REQUEST

Current Zoning: N1-B (neighborhood 1-B) and CG (general commercial)
Proposed Zoning: UR-2(CD) (urban residential, conditional)

Approximately 2.09 acres located on the northeast side of The Plaza, south of Bridgeport Drive, and west of Barrington Drive.

The petition proposes to allow an infill residential development with 26 single family attached (townhome) units on vacant land north of the intersection of The Plaza and Milton Road.

TECHNICAL  
DATA SHEET

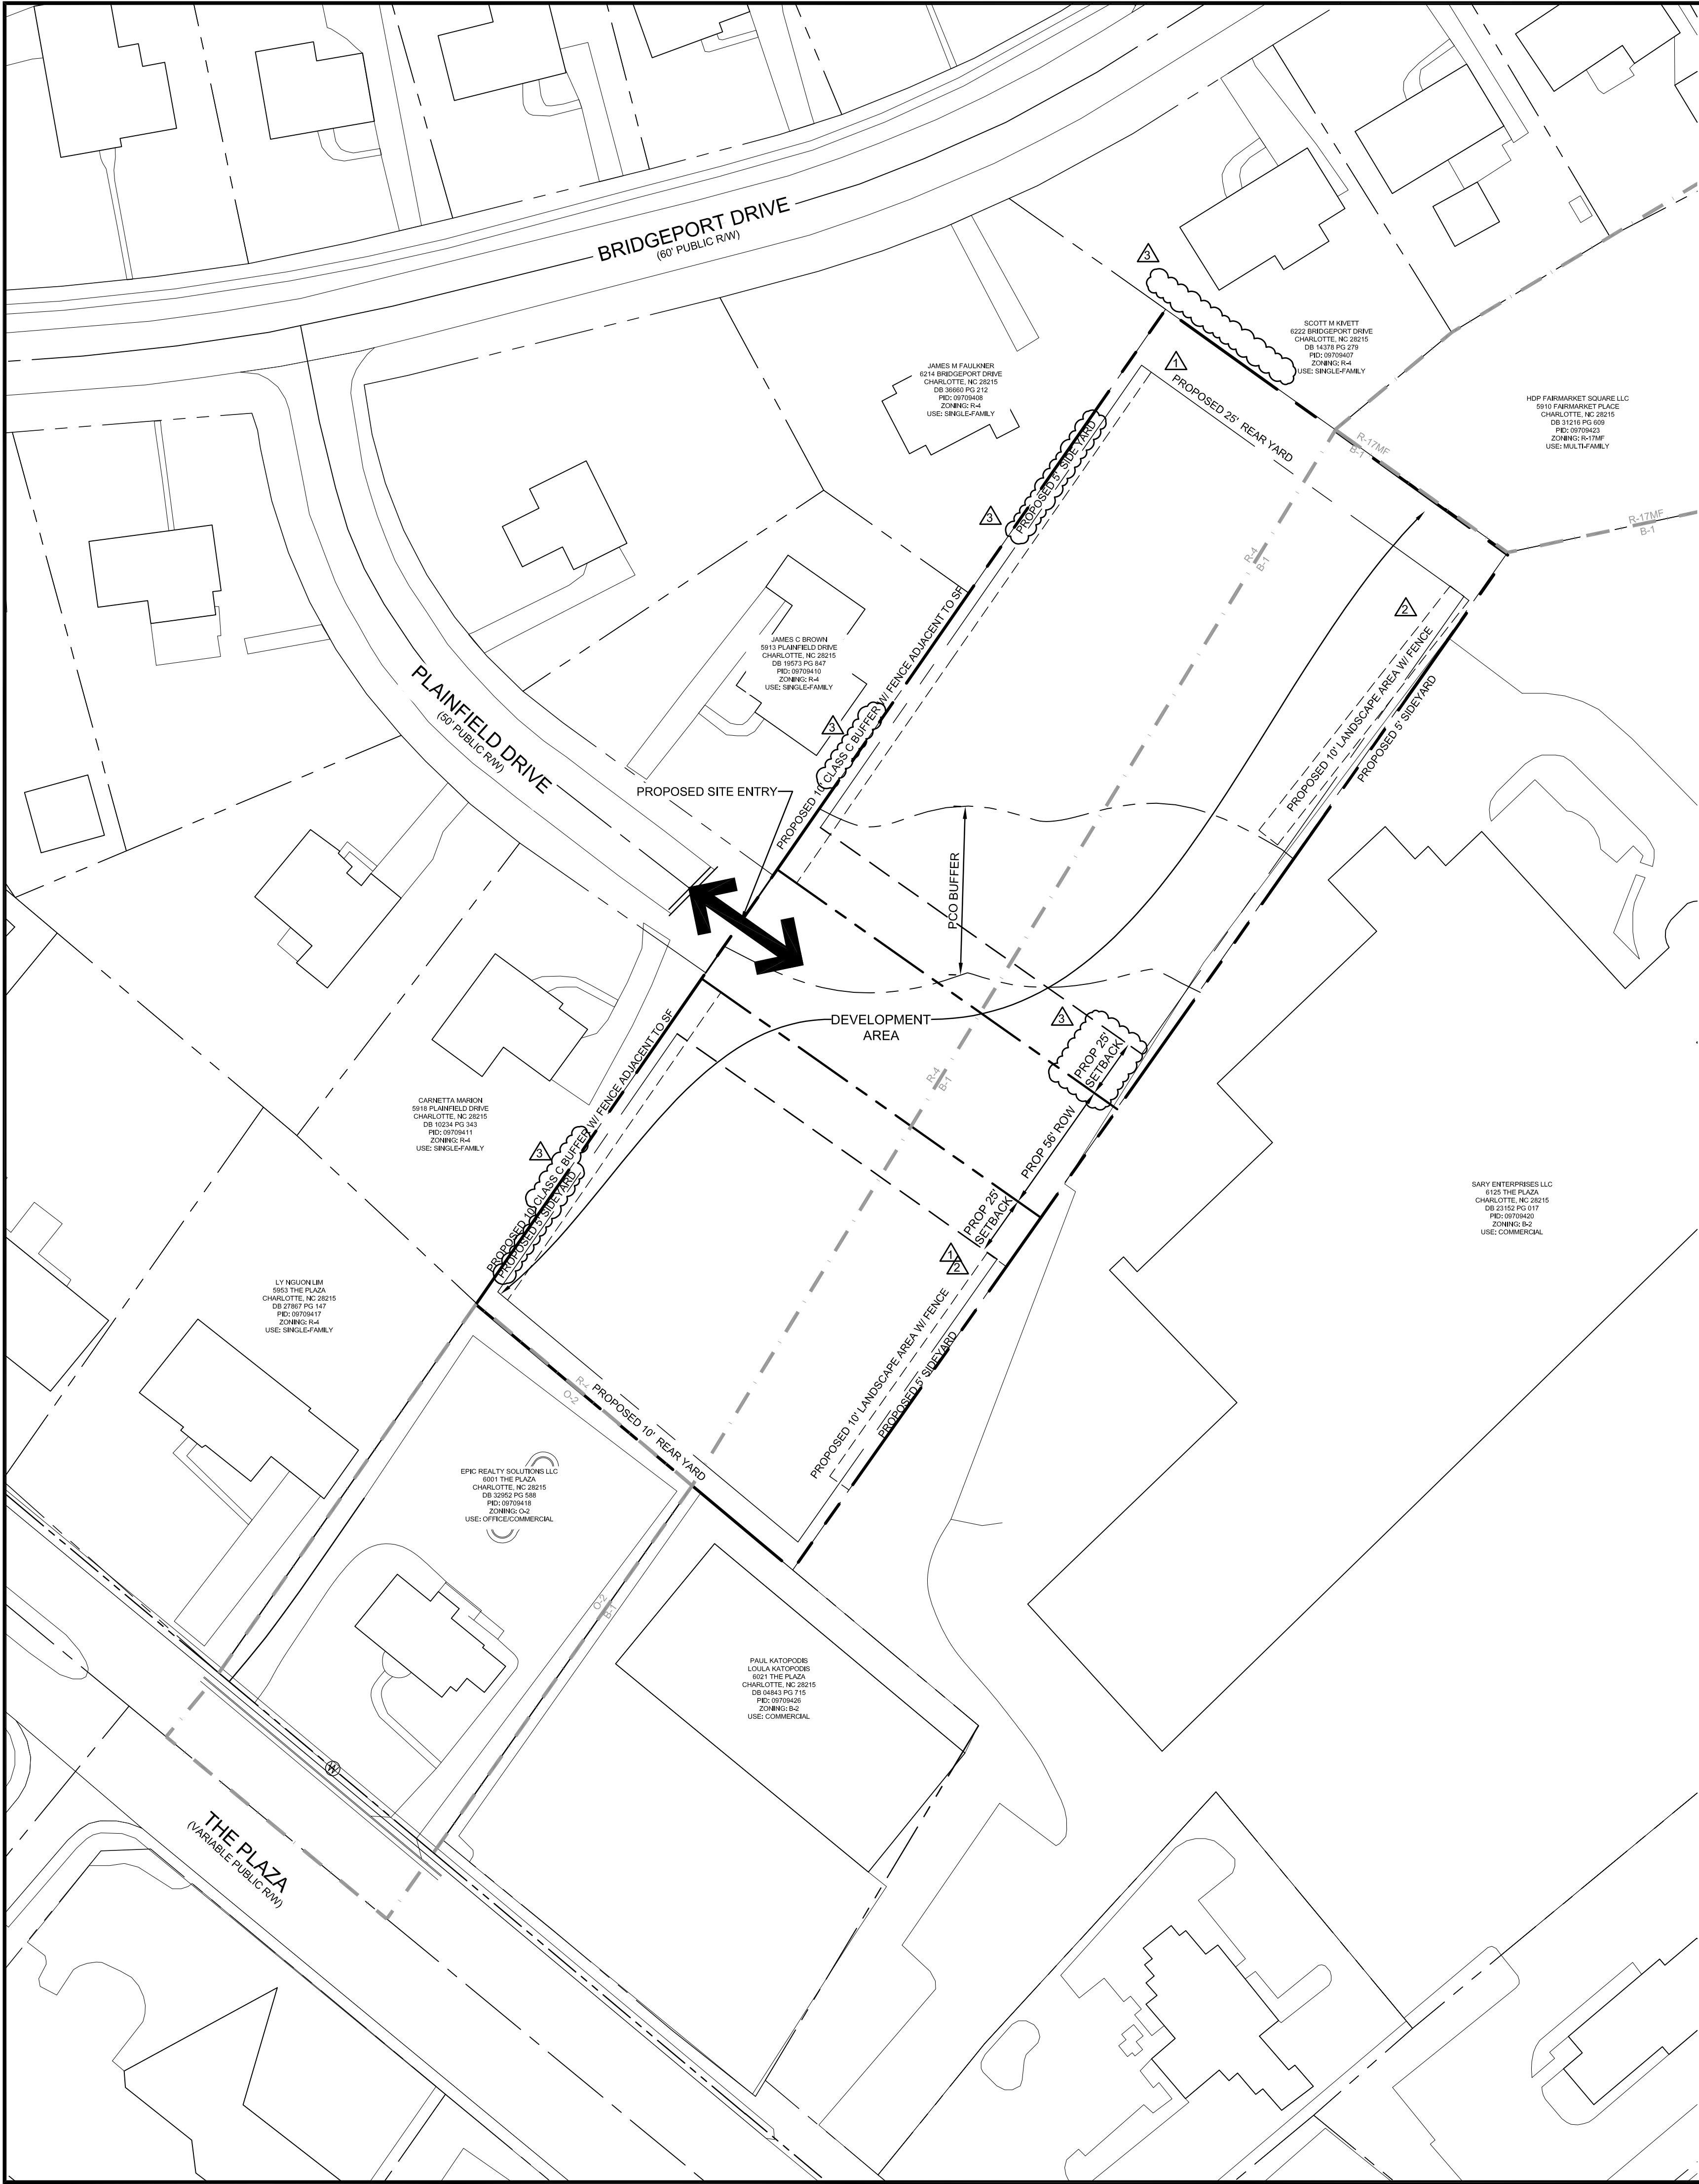
- ~~1. The proposed dwelling units exceeds 12 per acre. Per Chapter 20 Subdivision ordinance, site plan and conditional note(s) revisions are needed to commit to construct an 8-foot planting strip, and 8-foot sidewalk along all public roads. The wider sidewalk also meets the Charlotte WALKS Policy. Reference (CLDSM standard detail U-02) for residential medium street typical. Clarifying Comment 12-21-22: Petitioner should add conditional note stating commitment of 8' planting strip and 8' sidewalk along both sides of all public roads. Reference (CLDSM standard detail U-02) for residential medium street typical section. Potential environmental conflicts to be coordinated during permitting if full section cannot be achieved.~~

- ~~2. Ensure that tree save meets proper standards. Protected tree save should be roughly 30 feet wide. Any tree save not protected to meet the minimum requirements will need to be replanted at 150%~~

- Adds note stating the petitioner commits to construct an eight-foot planting strip and eight-foot sidewalk along both sides of all on-site public streets, in accordance with CLDSM standard detail U-02 (Residential Medium Street Section). Potential environmental conflicts shall be coordinated during permitting if full ROW section cannot be achieved.
